DELEGATED DECISION

Address: 68-76 ALBERT ROAD YIEWSLEY

Development: Creation of two additional floors above existing building to incorporate 4 x 1-bed flats (Prior Approval)

LBH Ref Nos: 33654/APP/2020/2582

PROPOSED PARKING AND CYCLE STORAGE (1:200)

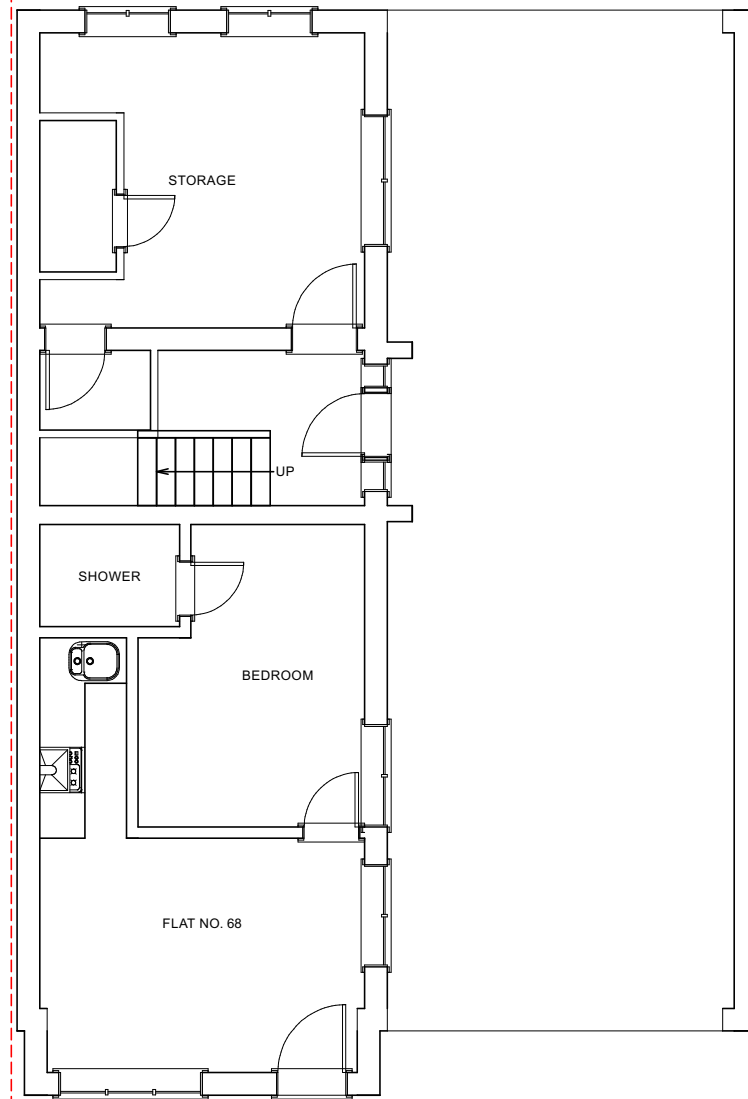
However, the Highway Authority are concerned that there is insufficient space for drivers to manoeuvre within the parking area at the rear of the proposed development. Manual for Streets (2007) advises that for perpendicular spaces, the area in front of parking bays should be 6 metres. The proposed development would only provide 5 metres. The Highways Authority are concerned regarding the restricted manoeuvring spaces in the proposed bays which would likely dissuade some residents from using the parking spaces, particularly if they are visiting their home for just a few minutes. This would displace parking on-street injudiciously presenting a risk to road safety, hindering the free flow of traffic and exacerbating parking stress in the locality.

To allay these concerns the Highway Authority asked the applicant to provide swept path drawings showing a car parking in each of the seven spaces. These drawings failed to demonstrate that a driver could safely and conveniently park in each space.

Whilst the number of cycle parking spaces proposed is policy compliant the Highway Authority considers that because they would be located at the front of the proposed development they will not be used. The cycle parking spaces in effect are located in the 'front garden' of the proposal immediately abutting the back of footway. In this location bicycles are vulnerable to being tampered with or stolen. The occupiers of the development are likely to consider that the risk of theft is so great that they would be deterred from owning one as they would have nowhere covered and secure to store it.

There are highway objections to this development as it is not in accordance with the Hillingdon Local Plan: Part 2 Development Management Policies (2020) Policy DMT 6: Vehicle Parking. There is insufficient space at the rear of the proposed development for vehicles to manoeuvre into every parking bay particularly when most spaces are occupied. In addition none of the car parking spaces are provided with electric vehicle charging points and the cycle parking provision is neither covered nor secure.

PROPOSED 3/F (1:100)

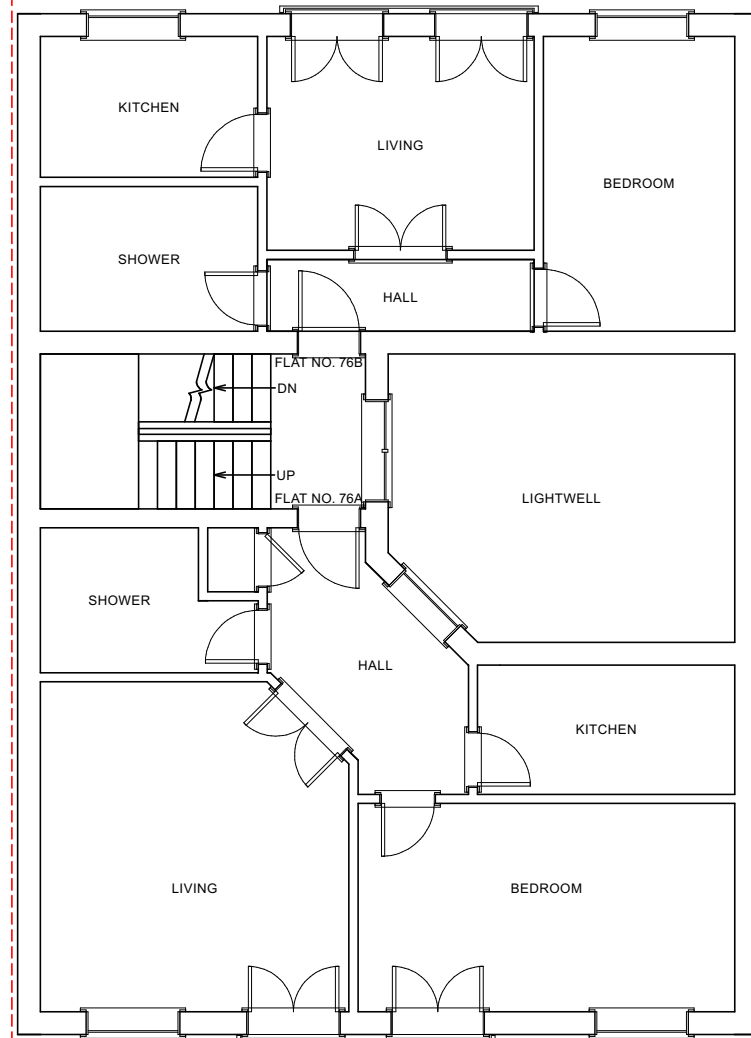
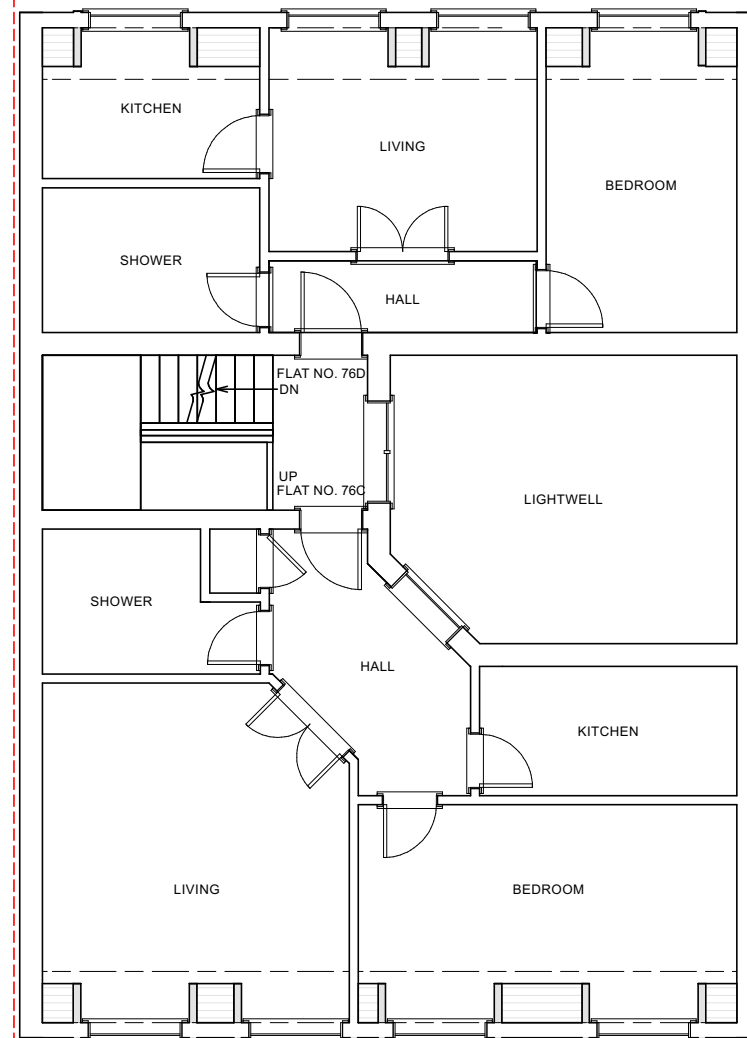
The exception to this is the provision of light and outlook to the kitchens in flats 76A and 76C which do not have any windows to allow light or outlook. As such the proposal fails to provide acceptable levels of light to the occupants of the two flats contrary to the requirements of Policy DMHB 16 of the Hillingdon Local Plan: Part 2 - Development Management Policies (January 2020).

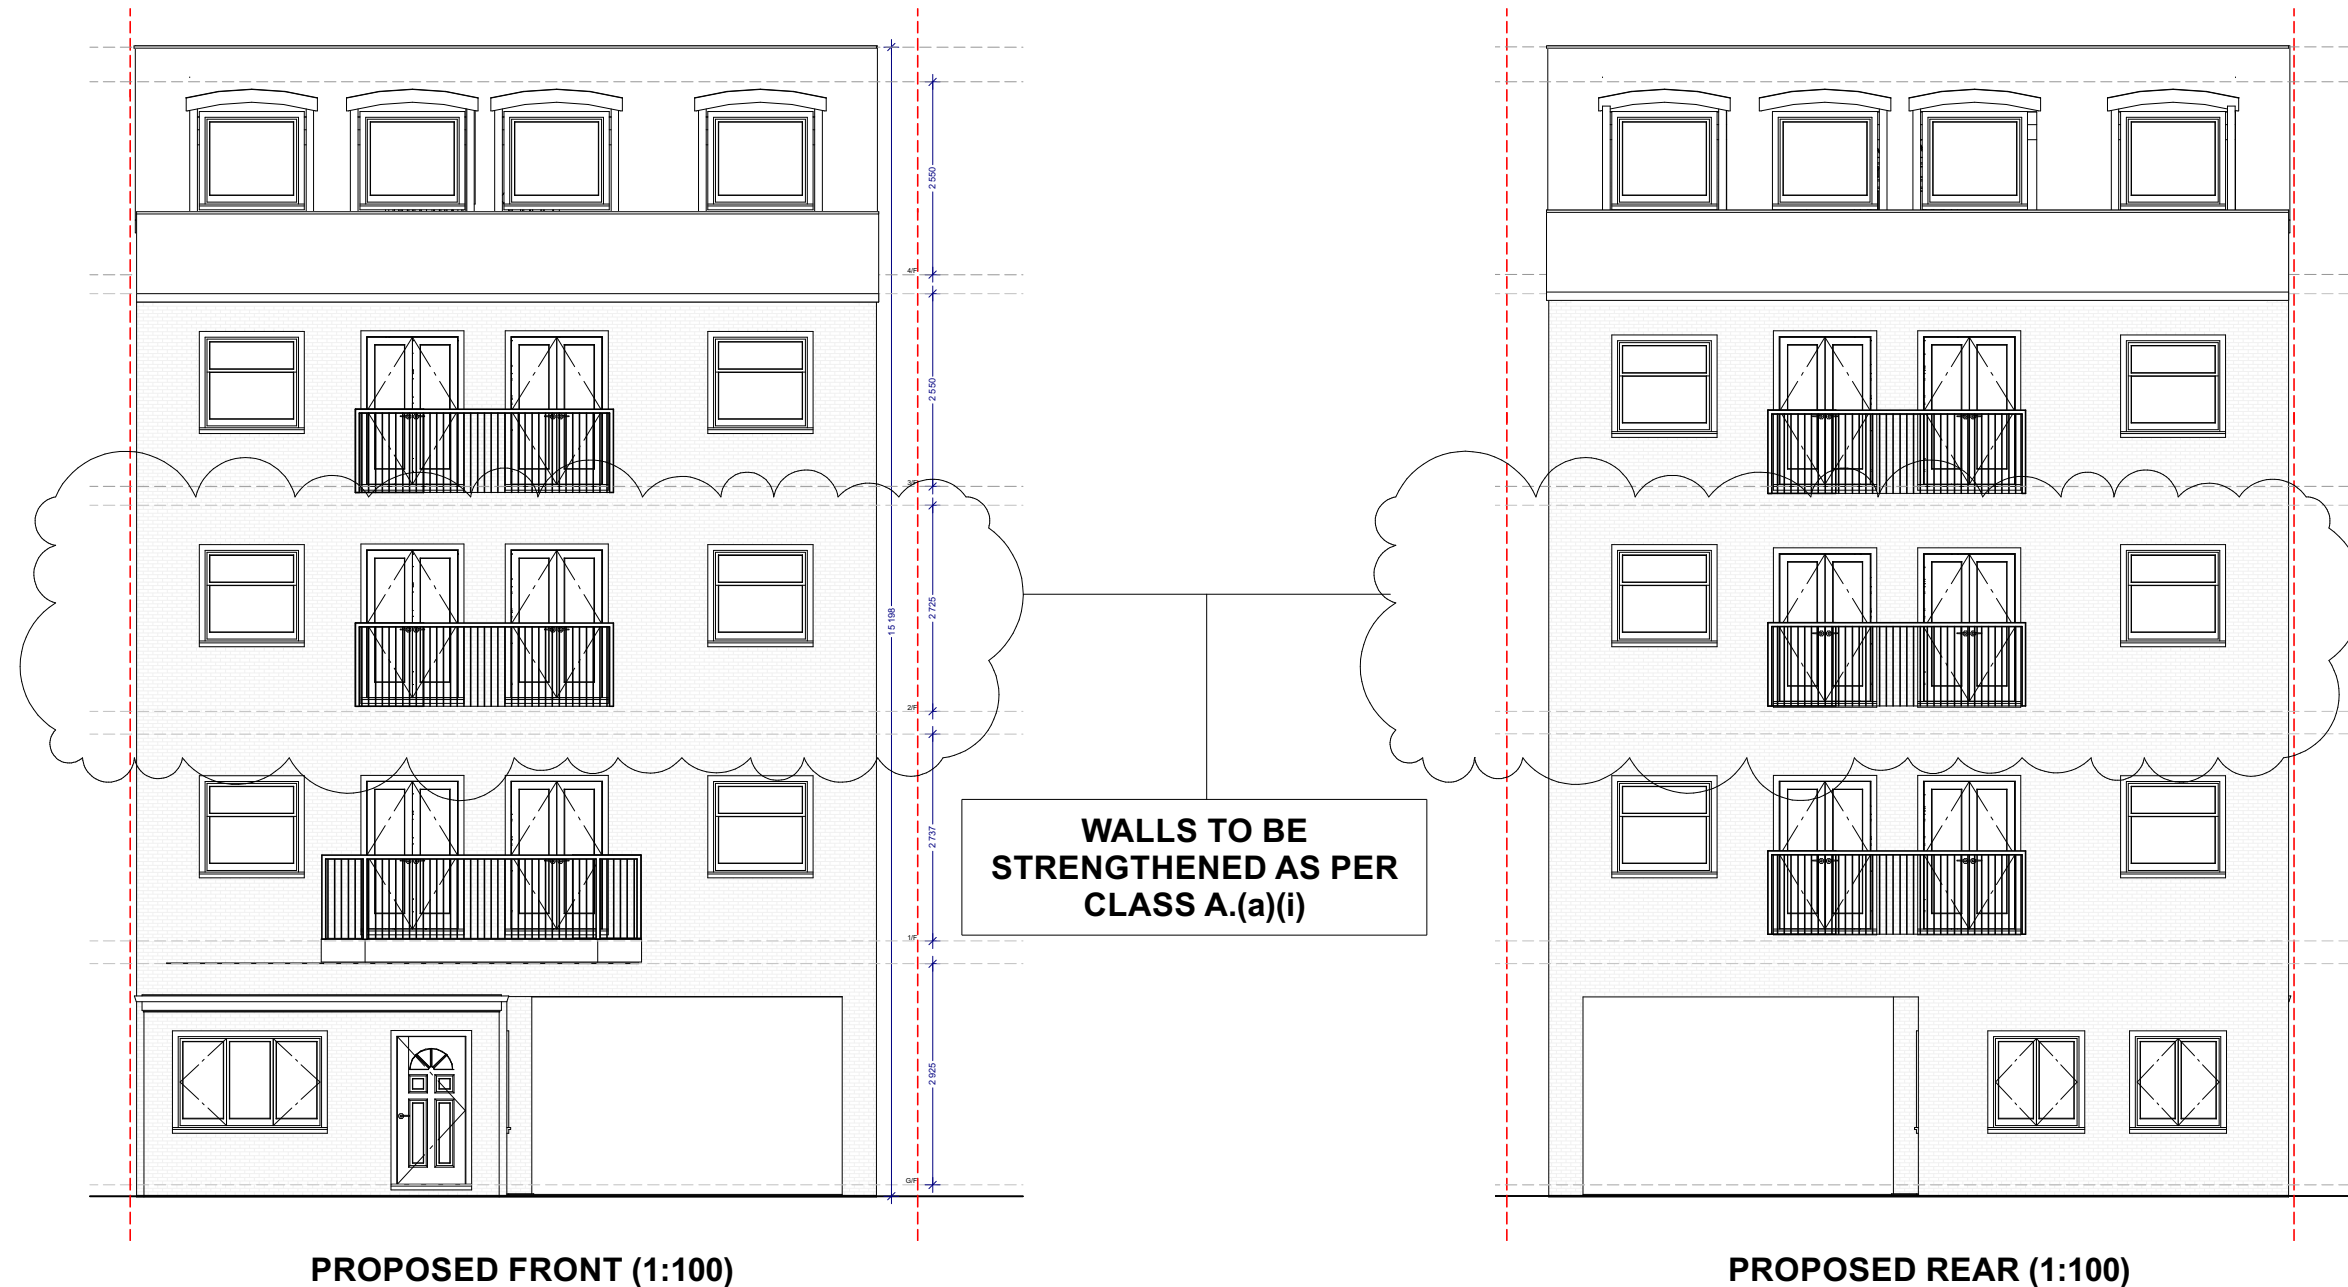
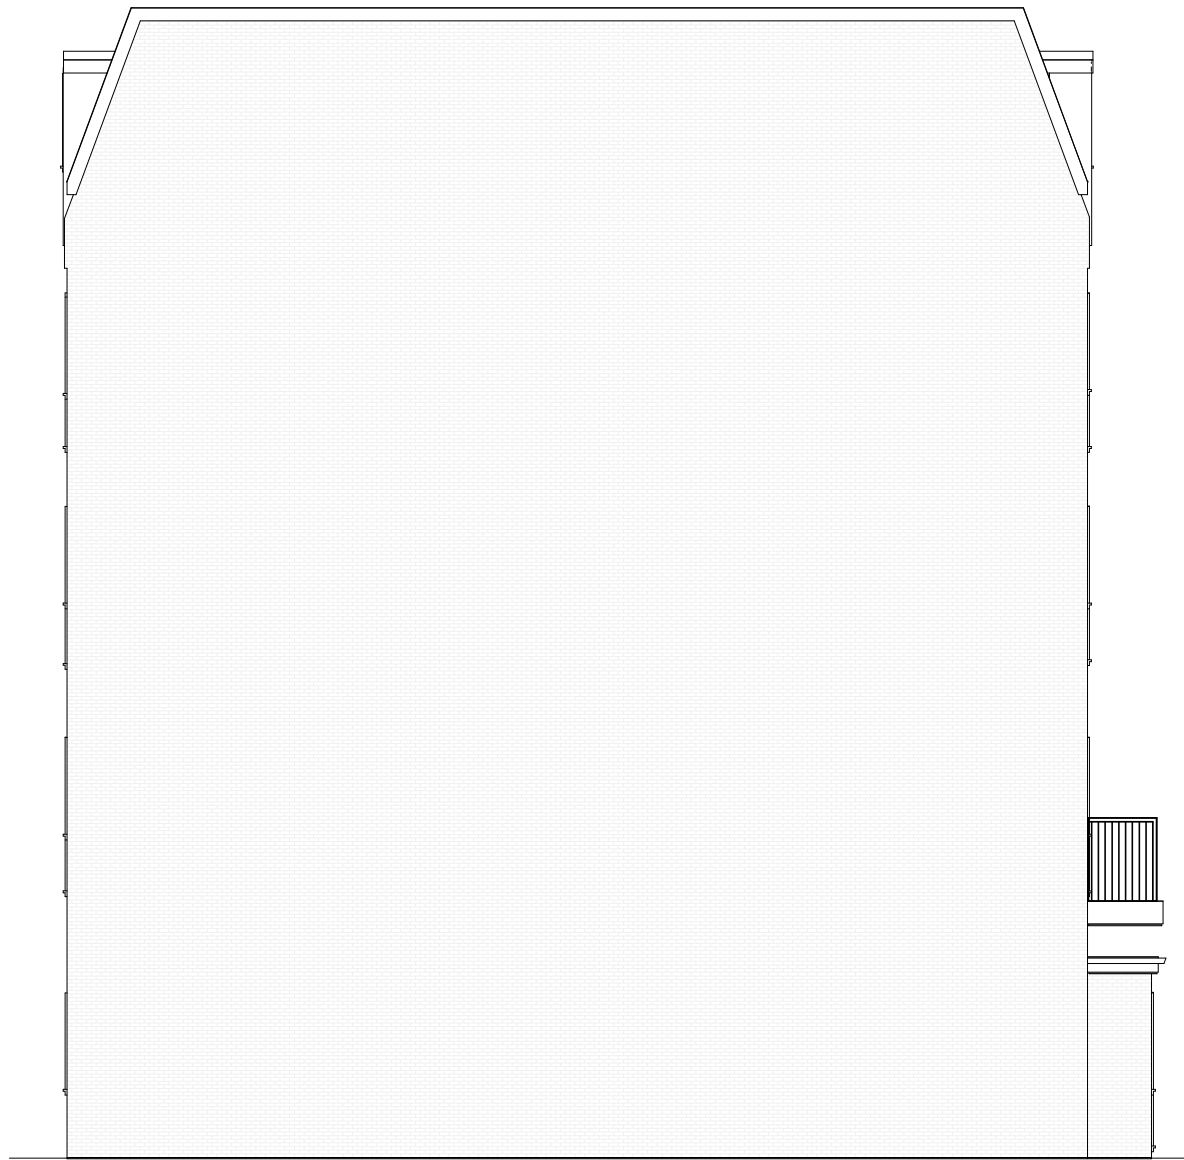
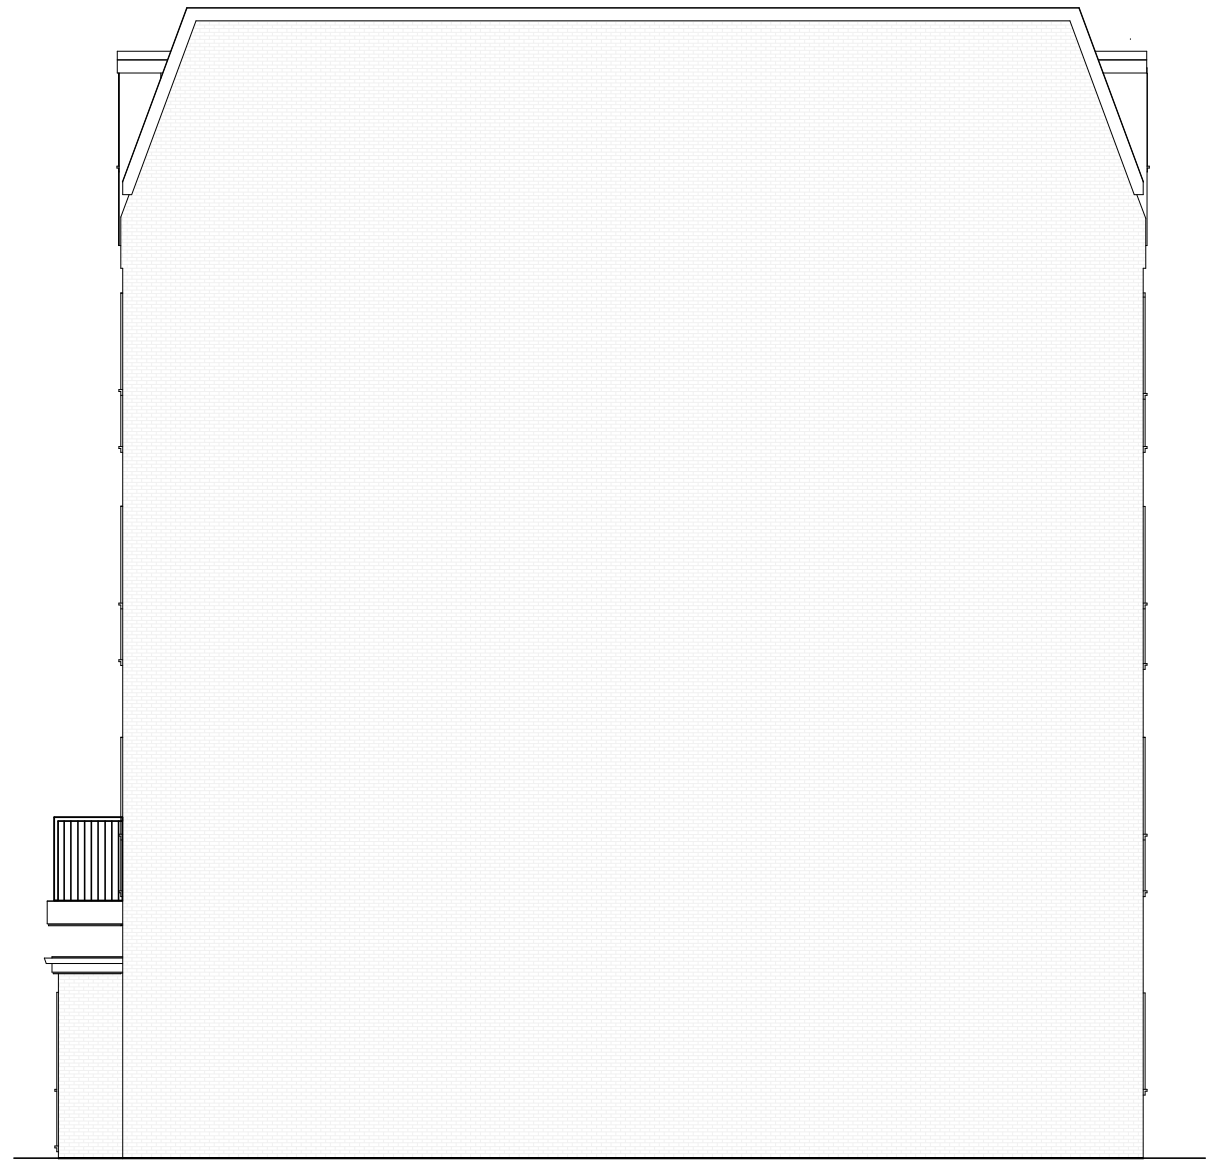
The application side of Albert Road is characterised by 3 storey buildings with a relatively uniform roof height. Two storey residential properties line the opposite side of Albert Road. The raising of the roof by adding two additional storeys with the associated additional height and bulk would result in a development that would be substantially taller than the surrounding properties, significantly changing the skyline on Albert Road. The proposed development would appear out of keeping with this row of properties and would represent a discordant addition to the streetscene in conflict with the requirements of Policy BE1 of the Hillingdon Local Plan: Part One - Strategic Policies (November 2012) and Policies DMHB11; DMHB12 and DMHD1 of the Hillingdon Local plan - Part Two (2020).

The properties opposite the application site at Numbers 59 and 61 Albert Road are two storey Victorian semi-detached houses with front facing bay windows serving habitable rooms. There is a separation distance of approximately 13m between the front wall of the neighbouring properties and the application property. The addition of two storeys to the application building would result in an overly dominant form of development which would detract from both the natural light levels and the level of outlook available to the occupants of Numbers 59 and 61 Albert Road, resulting in an unacceptable loss of amenity, in conflict with Policy DMHB11 of the Hillingdon Local Plan: Part Two - Development Management Policies (2020).
